Planning Application Ref: EP/2/19/T

Location: 'Scorton' 9 Lime Tree Close, East Preston, BN16 1JA

Description of works: Crown lift 3m all aspects, crown lift 6m on east aspect & back to boundary fence, selective & careful reduction of branches above 6m on east aspect by no more than 1m to 1 No. silver maple tree

TREES AT LIME TREE CLOSE, EAST PRESTON.
TREE PRESERVATION ORDER No. 4/1974. (EAST PRESTON)

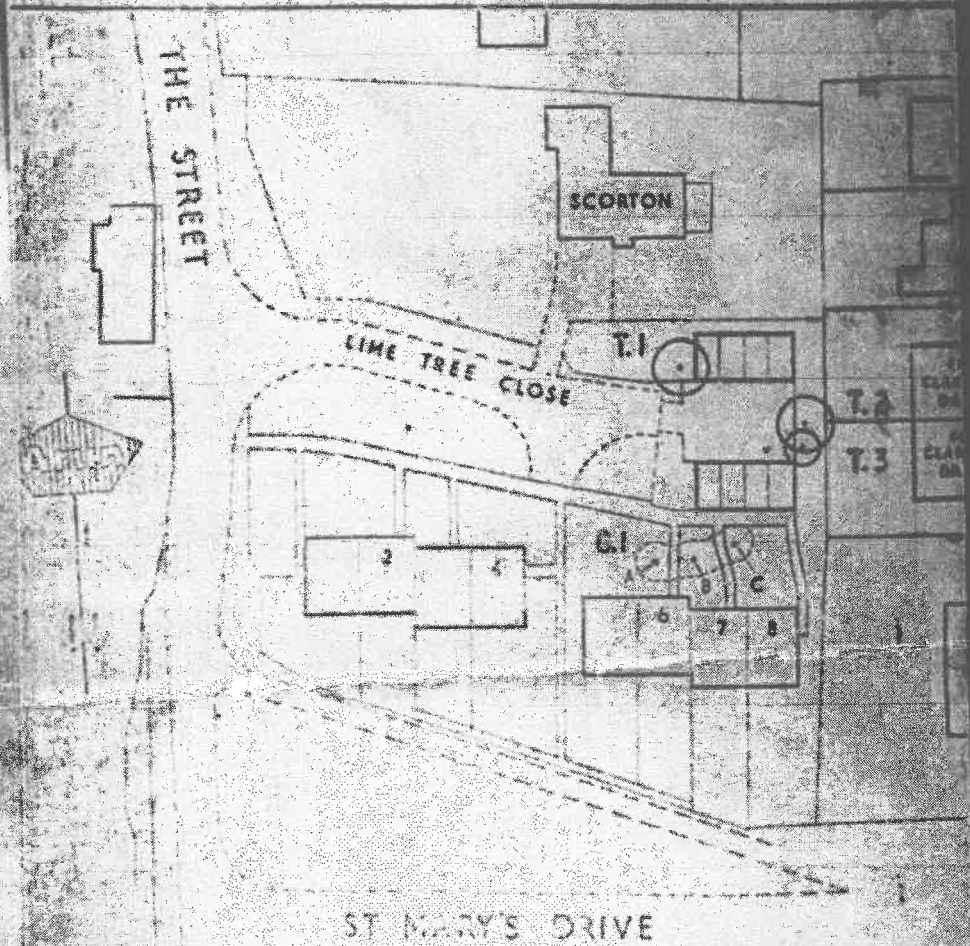
- The tree was unfortunately misidentified during the making of Tree Preservation Order (TPO/EP/4/74) although not so dissimilar as to raise doubt over it being the intended subject. This is reinforced by the original map associated with the Order and ground observations from site.
